**REF: 23/01503/OUT**

**Location: OS Parcel 1570 Adjoining And West Of  
Chilgrove Drive And Adjoining And North Of Camp Road  
Upper Heyford**

19 July 2023

Illustrative Masterplan

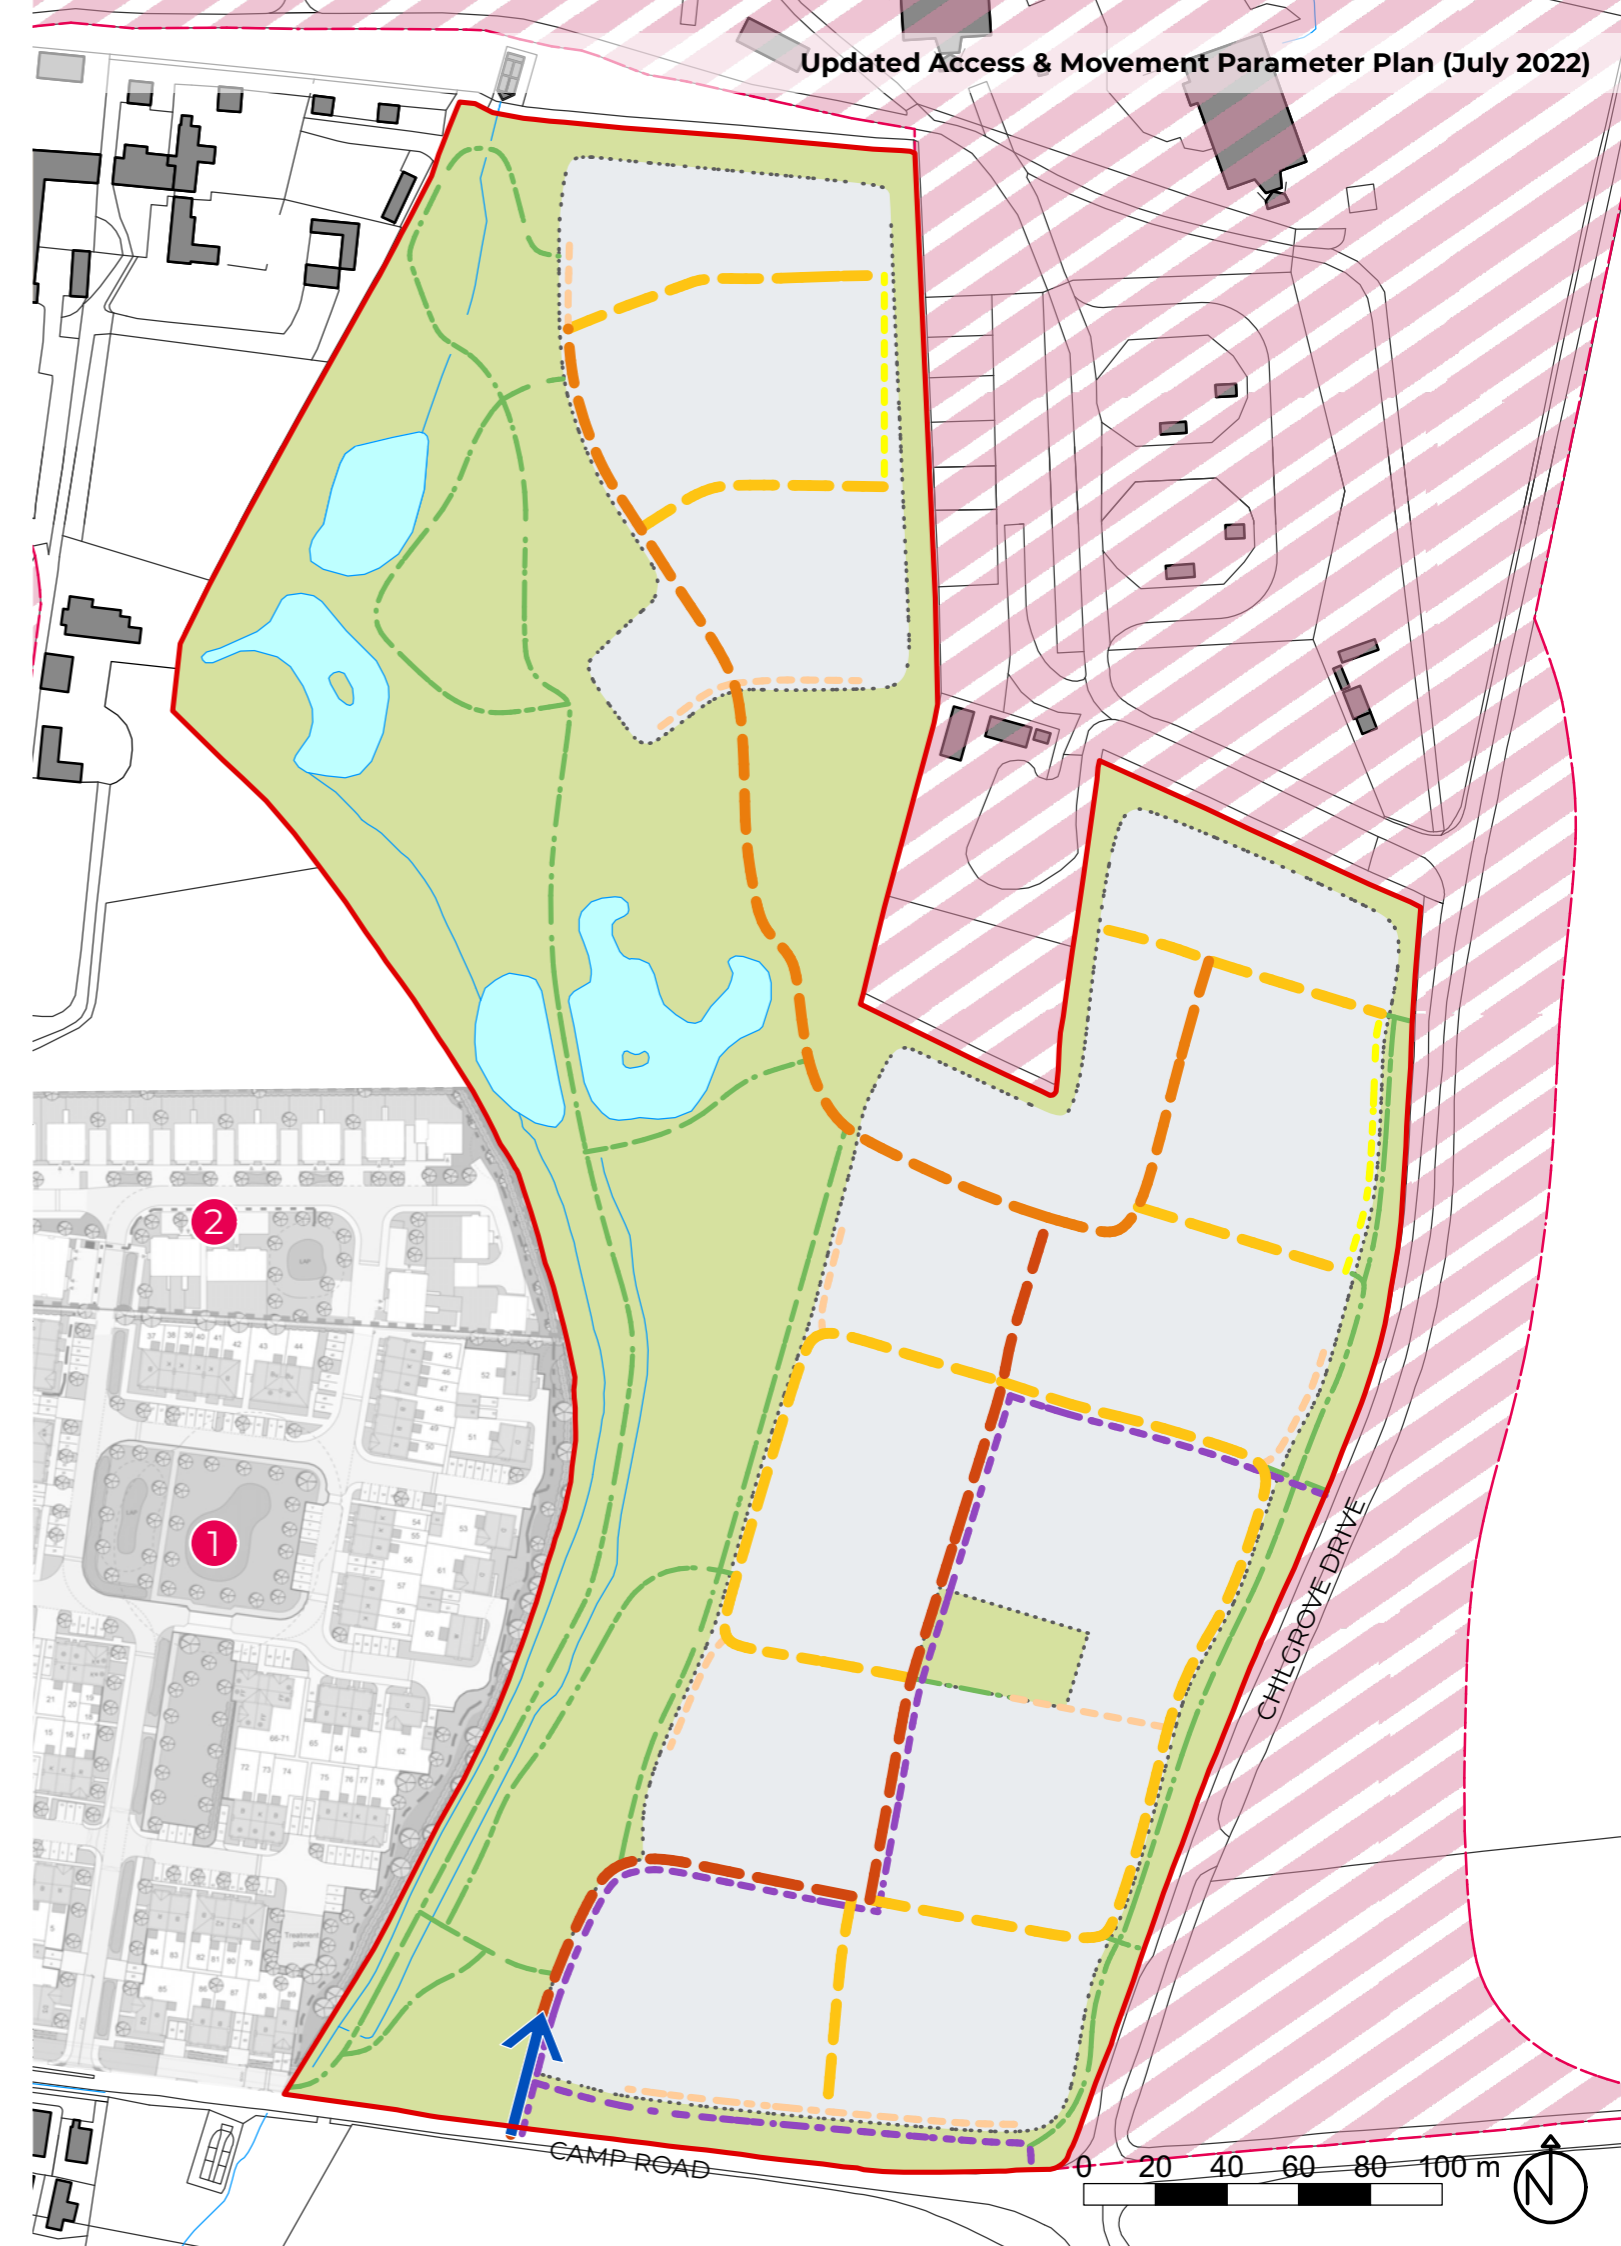
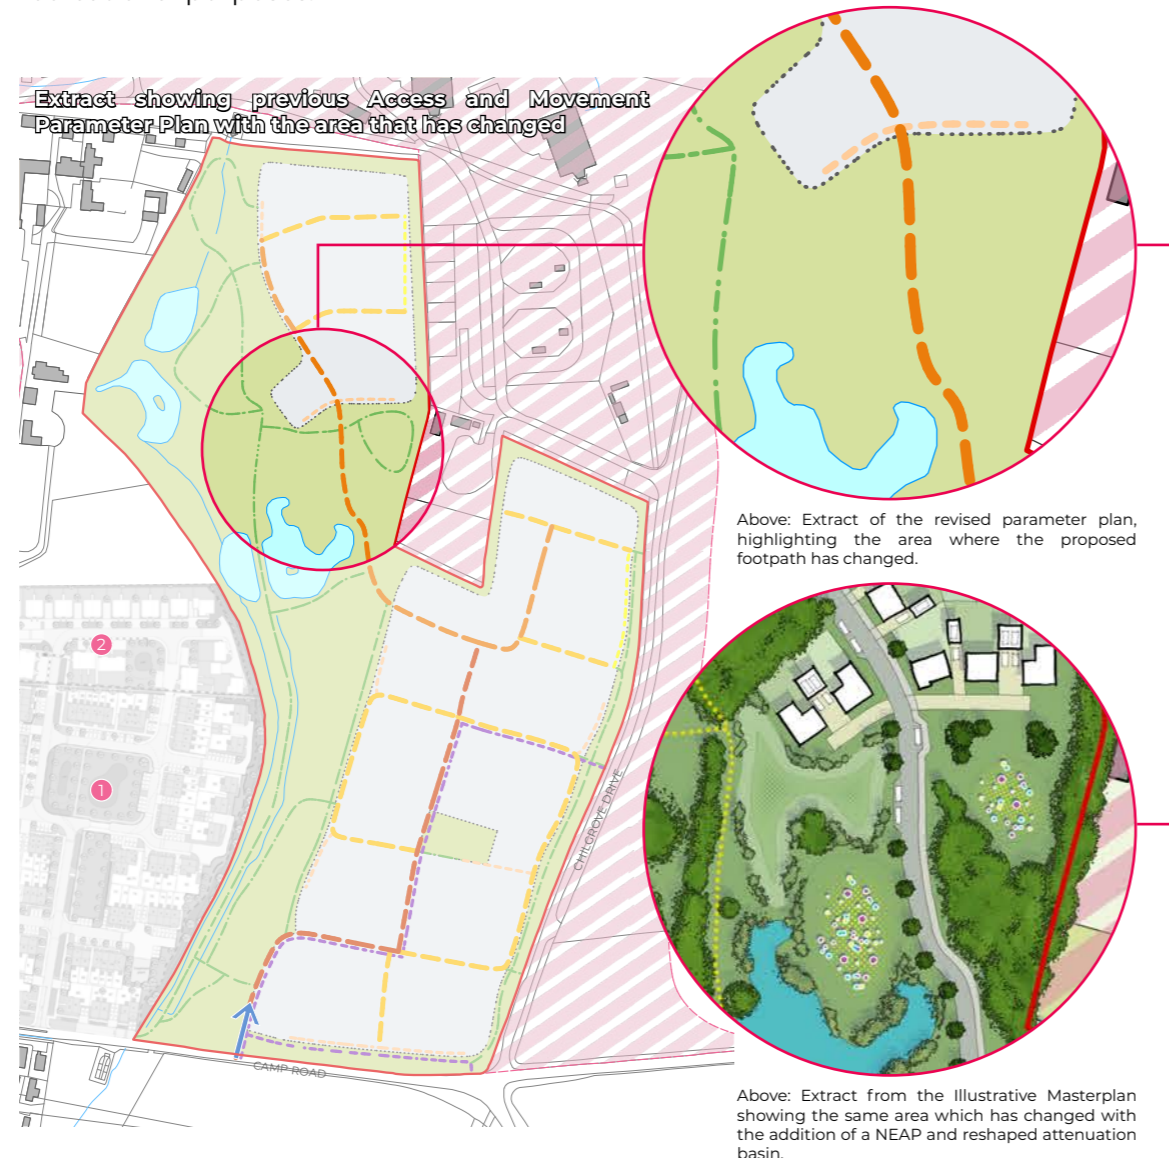
Thank you for consulting me on the above planning application. I have reviewed the amended plans and have concerns that the proposed NEAP and LEAP are not appropriately located and may be vulnerable to crime and ASB. Therefore I am unable to support this application in its current form.

It is important that any equipped play provision is located in an area well overlooked by high levels of surveillance from surrounding residential dwellings, to provide the facilities with appropriate guardians who will be able to identify and challenge or report crime and antisocial behaviour. The proposed location of the areas of play prevents this, leaving them likely targets for crime and ASB, and damage such as graffiti. Planting and landscaping surrounding equipped areas of play must also facilitate clear sightlines over the facilities from neighbouring roads and dwellings, again to enhance surveillance and reduce opportunities for crime and ASB. Planting surrounding these areas should only include clear stemmed trees with canopies maintained above 2m, and low level hedging maintained below 1m in height. The proposed location of the facilities hides them from view behind vegetation (Particularly the LEAP).

I ask that prior to permission being granted, the NEAP and LEAP are relocated to an area where they are well overlooked by high levels of surveillance from surrounding development.

*Whilst all matters are reserved except for access, I provide the following comments on the submitted illustrative masterplan for the applicants reference;*

- *The primary route through the development is formed primarily with a long, relatively straight section of road. This creates a risk that speeding through the development will easily occur. I recommend ensuring this road is laid out and designed to minimise the risk of speeding, through the use of landscaping, surfacing and deviations in route to reduce the speed of vehicles.*

- *The secondary street connecting the north and south residential areas will be a primary route for pedestrians and cyclists, and therefore it must be promoted as a safe route with lighting along the entirety of the route, which should conform to BS 5489-1:2020, including sections through green space. Proposed tree planting must take lighting into consideration to avoid areas of pooling and shadowing of light at night which can support and create a fear of crime. Sections of the route leave pedestrians vulnerable to crime and ASB, particularly around the pond area where a bend in the road reduces surveillance. I recommend this route is designed with surveillance in mind, and surrounding vegetation and residential development should be utilised to open up and maximise views over this route from both ends.*

- *Footpaths through public open space and wetlands, particularly to the west of the development, may be at risk of crime and antisocial behaviour, due to a lack of surveillance from surrounding developments where vegetation prohibits this. It is important that footpaths provide clear sightlines and have a sufficient width to prevent vegetation restricting views for users, and they should be protected by surveillance from surrounding residential development. Footpaths such as these should not be lit at night, to encourage pedestrians to use primary safe routes which are well lit and overlooked.*

- *The pedestrian connection to camp road at the south-eastern corner of the site (running along the eastern boundary) must be designed with surveillance maximised from surrounding dwellings. Sections running alongside vulnerable side boundaries of gardens lack surveillance, leaving the boundary vulnerable and reducing surveillance over pedestrians using the link. Building orientation and windows in gable ends should be carefully considered to maximise views over pedestrian/cycle only links such as these. Defensible space and planting to a depth of at least 1m must be provided to side or rear boundaries adjoining public footpaths, as well as to any easily accessible ground floor windows.*

- *I have concerns with proposed parking which is located in an isolated position to the rear of several back gardens where it is lacking surveillance from owners. This leaves the vehicles and property boundaries vulnerable to crime. Surveillance is further reduced in this area by the proposed on-street parking which reduces surveillance from ground floor windows of dwellings. I recommend this area of parking is reconsidered prior to submission of further applications;*

- *I would recommend splitting up and relocating areas of visitor parking around the site, on street where it is covered by high levels of surveillance from surrounding dwellings. Concentrating stretches of on-street visitor parking together alongside footpaths (highlighted on the illustrated master plan next to 6 for example) creates a risk vs reward imbalance for an offender, which creates an attractive target and leaves vehicles vulnerable to crime. Visitor parking lacks ownership, which prevents residents identifying or challenging an offender.*
